Rezoning Transportation Analysis

Petition Number: 2020-120

General Location Identifier: Tax ID (02962106)

Date	Description
09-11-20	First Review
10-19-20	Second Review

REZONING PLAN
RZ.01

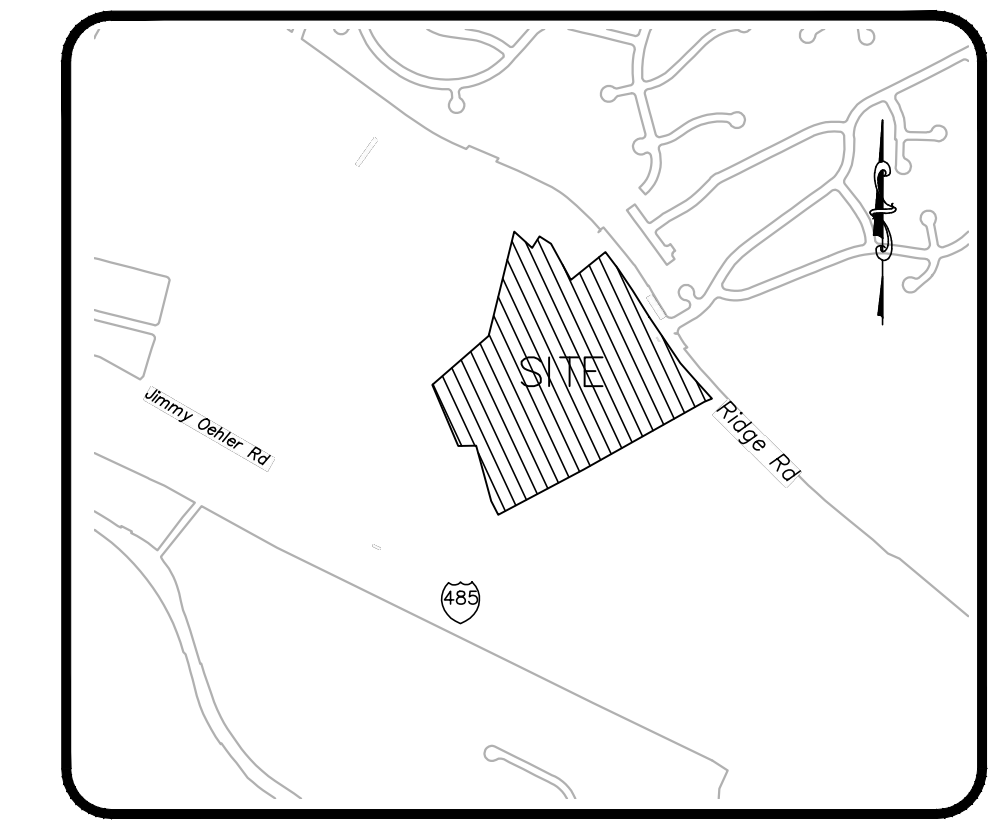
Label and dimension the curb and gutter from the centerline for each road.

8. **New comment (site plan dated 10.12.2020):** The petitioner should revise the site plan and conditional note(s) to update the proposed curb line, 8-ft planting strip, and 12-ft multi-use path, according to the redlines shown below. After additional review of the approved plans for SDRMFR-2019-00041 - Redwood Ridge Road, the development is providing an 11-ft center turn lane, as opposed to the 10-ft center turn lane that was recommended within the Prosperity Hucks Area Plan.

9. **New comment (site plan dated 10.12.2020):** The petitioner should revise the site plan to accommodate a private driveway designated for the future solid waste and recycling center, that allows space for all garbage truck turning movements to occur within the private drive, without maneuvering within the public right-of-way.
